## KITTITAS COUNTY COMMUNITY DEVELOPMENT SERVICES

May 25<sup>th</sup>, 2018

RE: North Fork Accessory Dwelling Unit (AU -18-00001) Transmittal of Comments

**NORTH FORK RANCH SITE PLAN**

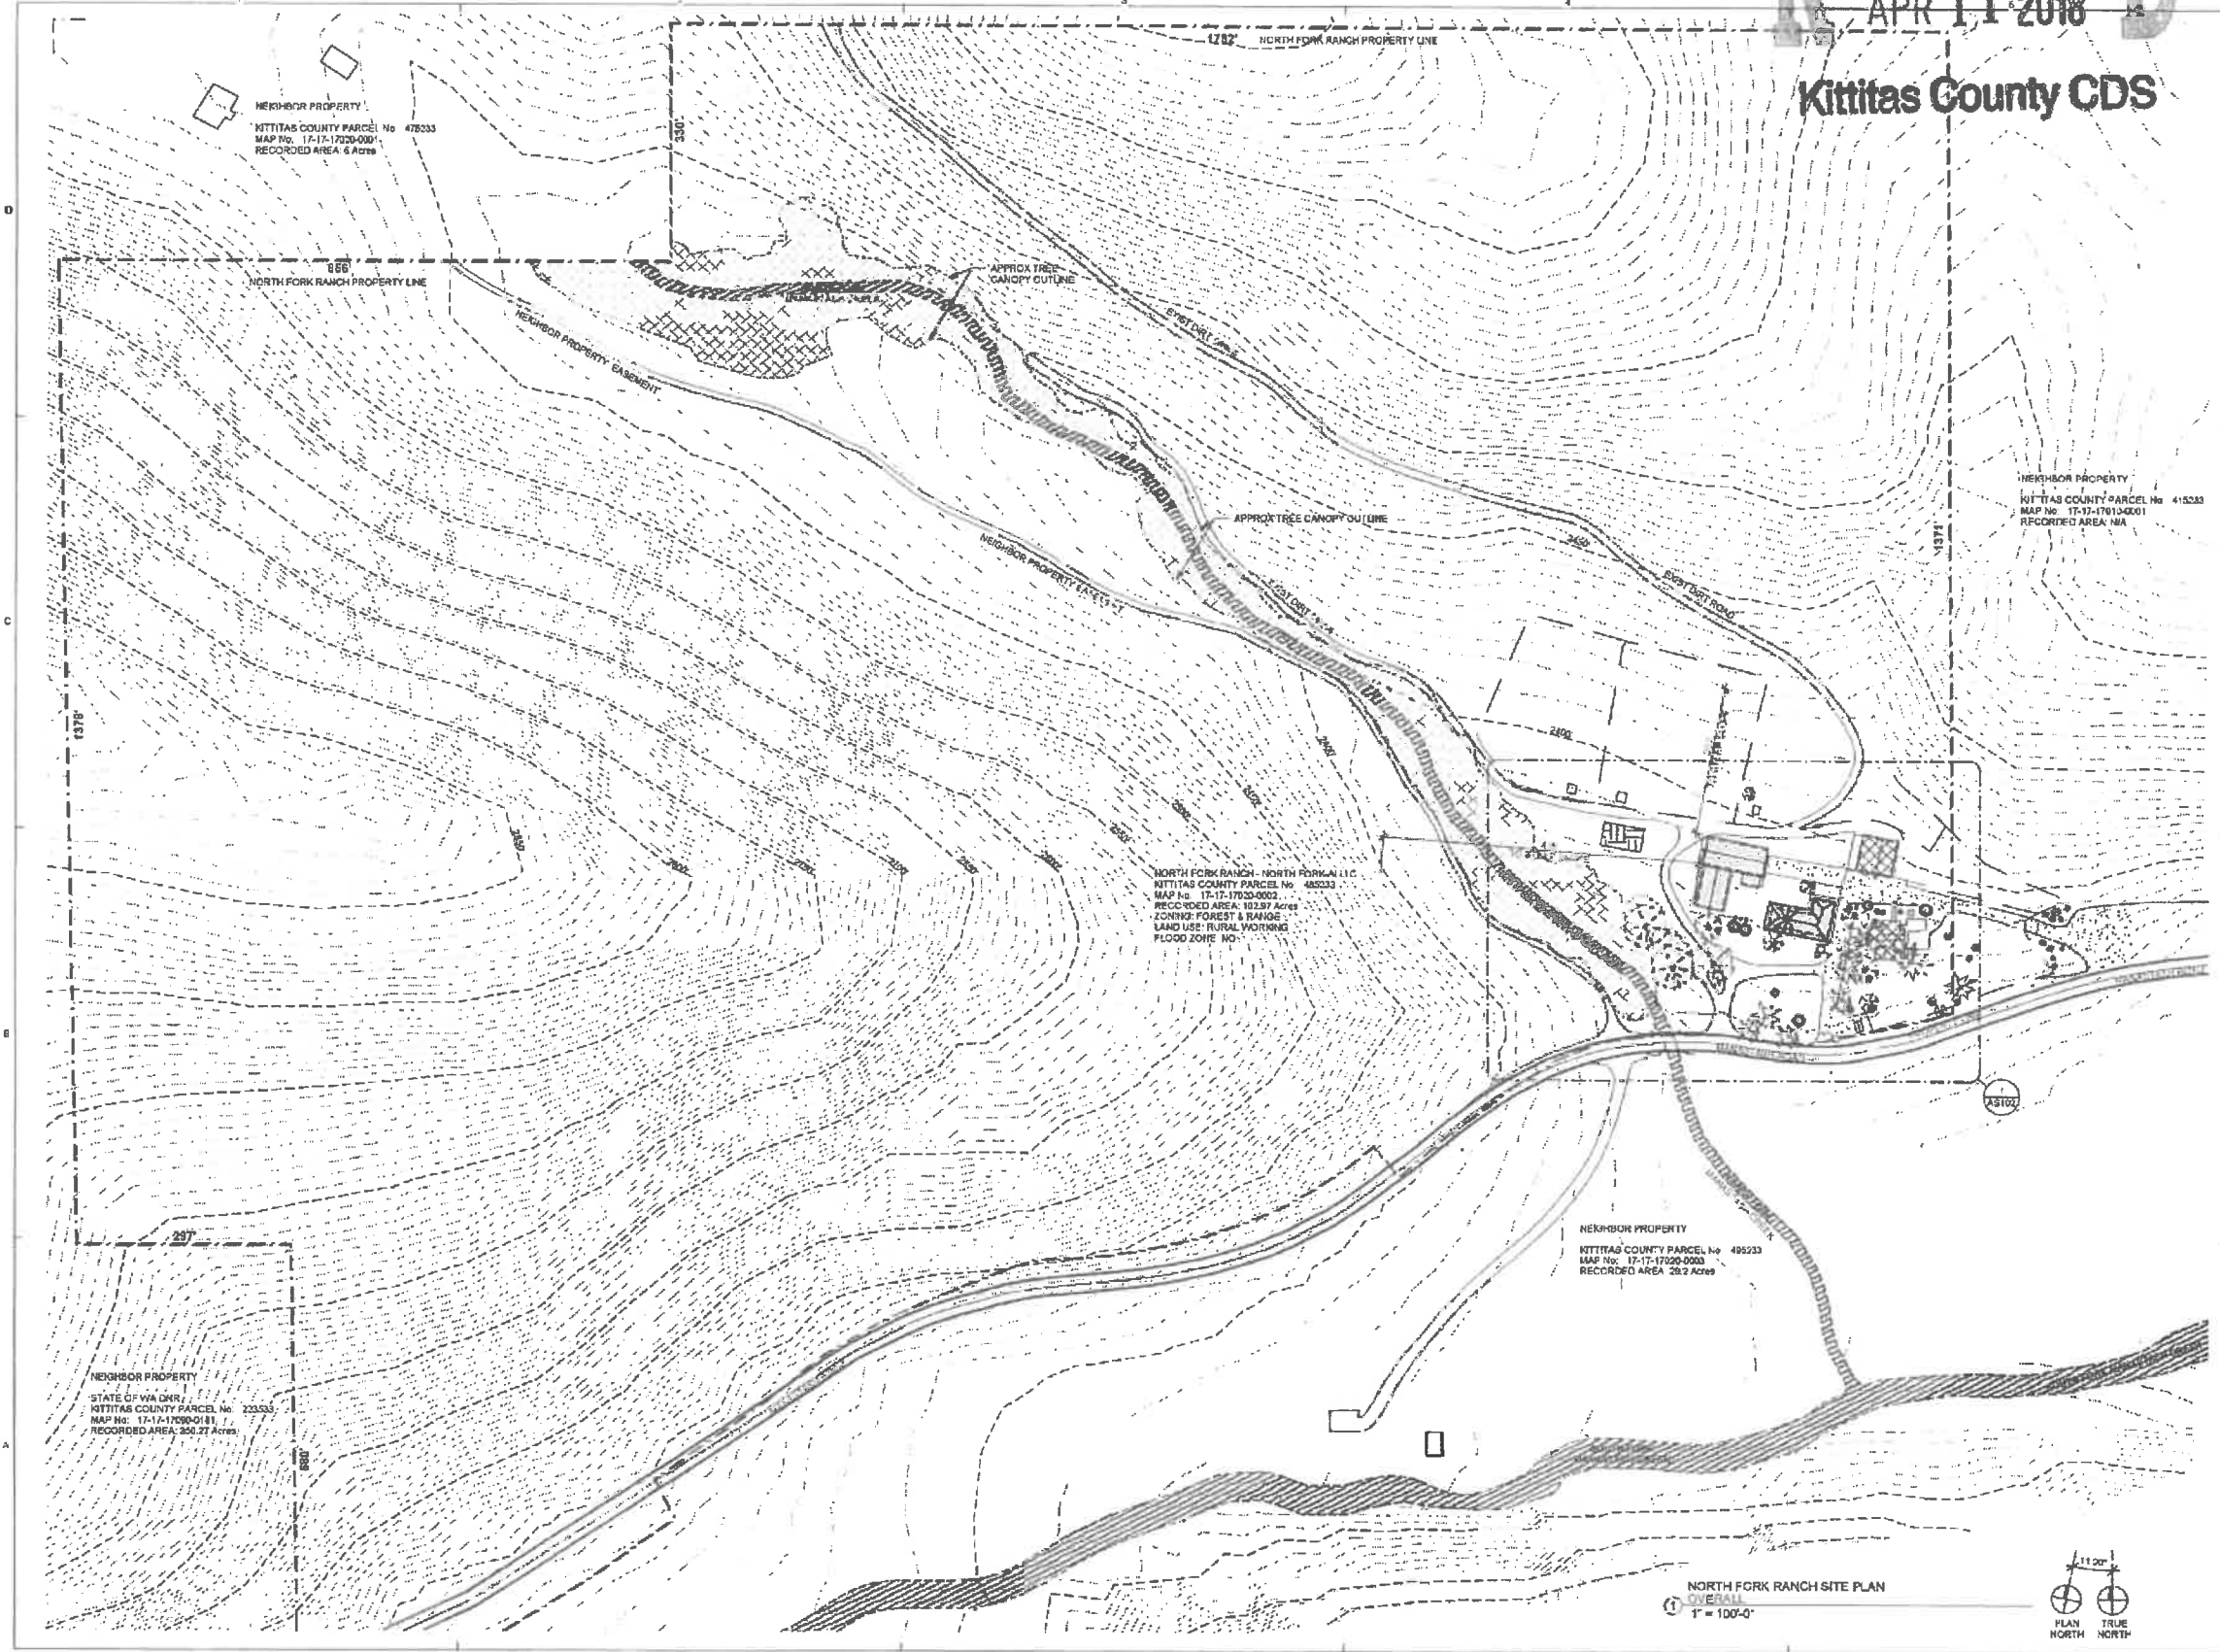
2. The Bunk House appears to be only a couple feet from an "Existing Well Building". For public water systems, DOH requires a clear 100 feet radius Sanitary Control Area around wells.

3. Where are the sewerage components in the Bunk House (toilets and sinks and showers – and their associated waste piping)? Please see Comment 2, above, for DOH requirements (for a public well).
